Address: 1 Stainecross Avenue Huddersfield HD4 5HZ

Application number: 2024/92983	
What is the application for?:	Erection of detached garage (part retrospective)
Address of the site or building:	3, Stainecross Avenue, Crosland Moor, Huddersfield, HD4 5HZ
Postcode:	HD4 5HZ

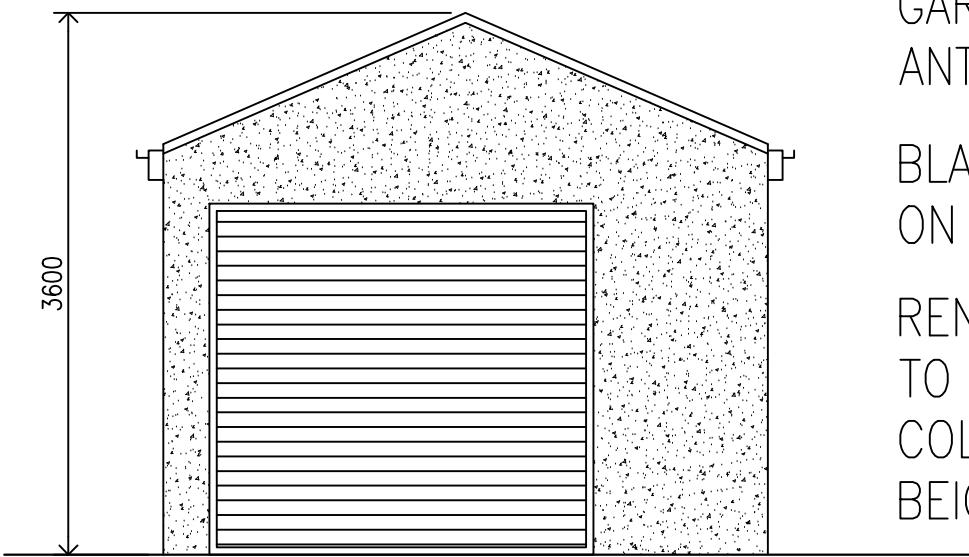
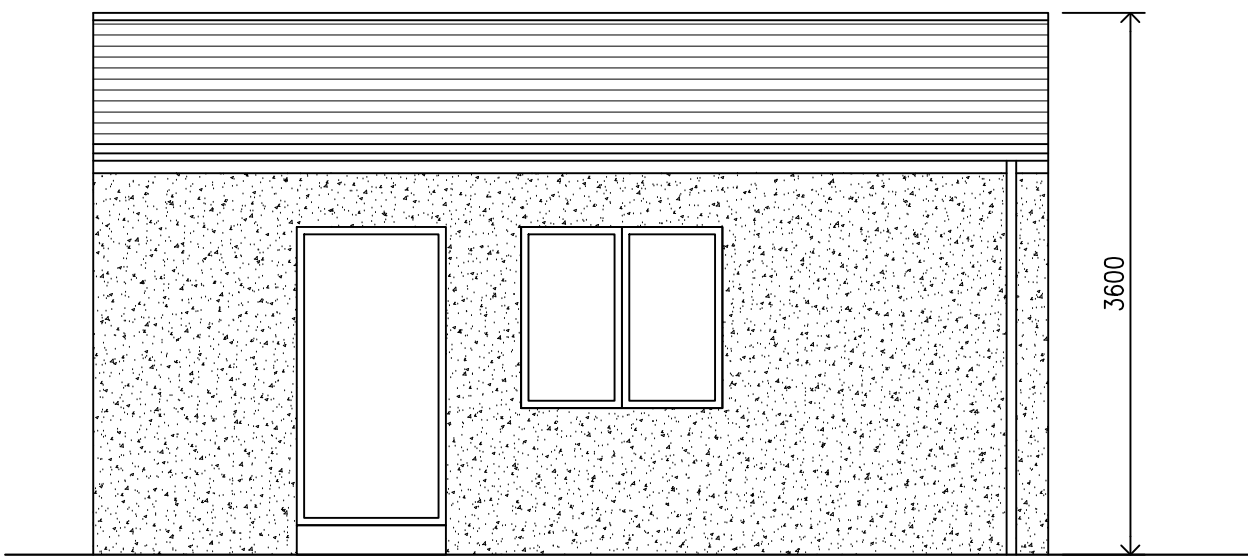
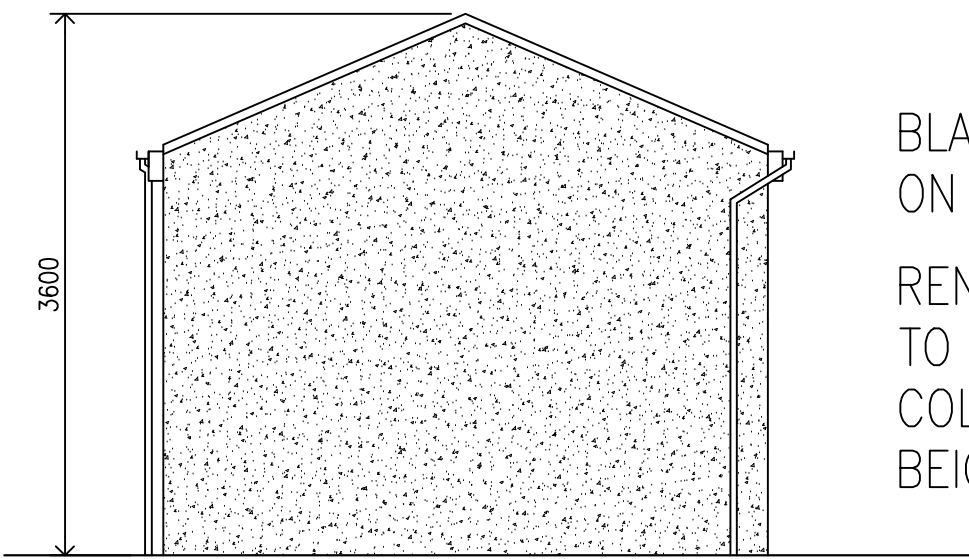
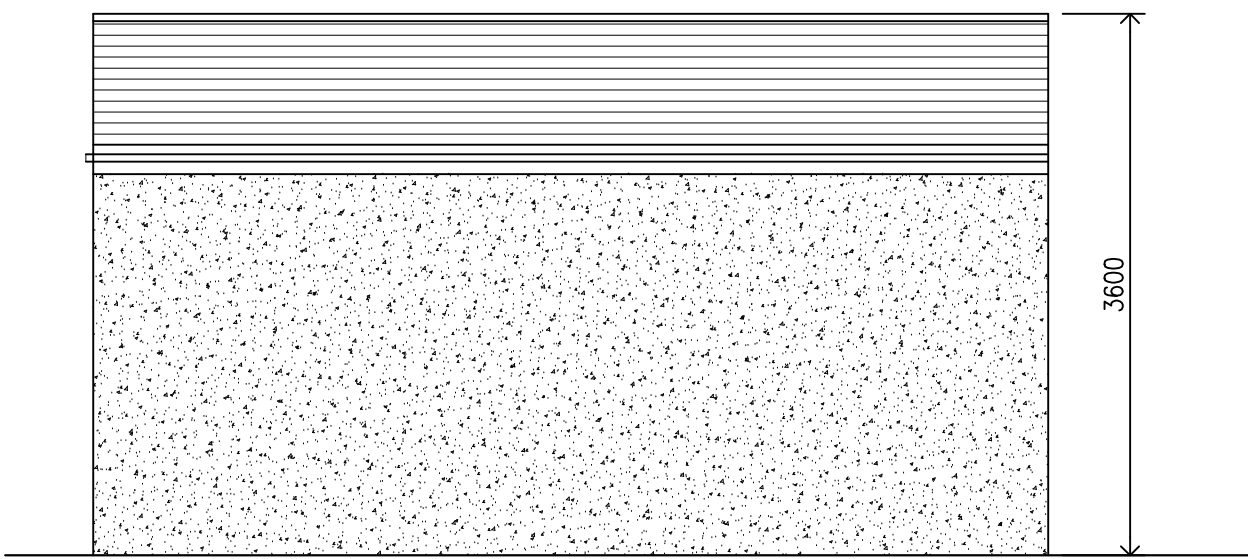
Type of comment: An objection	
Do you wish your comments to be published on the website anonymously?	No
<p>Currently, there is evidence at 3 Stainecross Avenue, Huddersfield, that D Shad submits plans. Currently there is a building there that has been refused planning permission. The original garage was supposed to be relocated further back away from the house, it had a flat roof, and it had a wall that was separate from the shared boundary wall. He has built a building that crosses the boundary line. The original shared boundary wall, that starts at Stainecross Avenue, for more than 40 years has been sandstone bricks. On the neighbouring 1 Stainecross Avenue garden side he extended the shared boundary wall using gray breeze blocks, because in previous planning documents they stated that "same as existing" materials or bricks would be used. Also now he has used the boundary wall as part of the new "garage" building, causing the roof to cross the boundary line. The original garage had a flat roof where all rain water flowed into the 3 Stainecross Avenue garden. At present there is a building there with a pointed upwards, dual pitched, open Gable type roof, where the roof crosses the boundary line and where for this past year and currently water flows from this roof into the neighbouring 1 Stainecross Ave Garden. Therefore I object to this type of roof, and the original garage flat roof should be installed instead, or the flat roof legally enforced and implemented, as was the original garage roof. Also he used lower quality breeze blocks on the neighbours 1 Stainecross Avenue side for the wall, then for the other garage walls (for the current garage building), he has used better quality sandstone bricks for walls at 3 Stainecross Avenue. As we know, in this new plan, it states "render to wall colour beige", in a previous garage plan it stated rendering, but D Shad did not render. D Shad and his architect should submit plans to what going to build. They should submit a new plan with the sandstone bricks that going to use.</p>
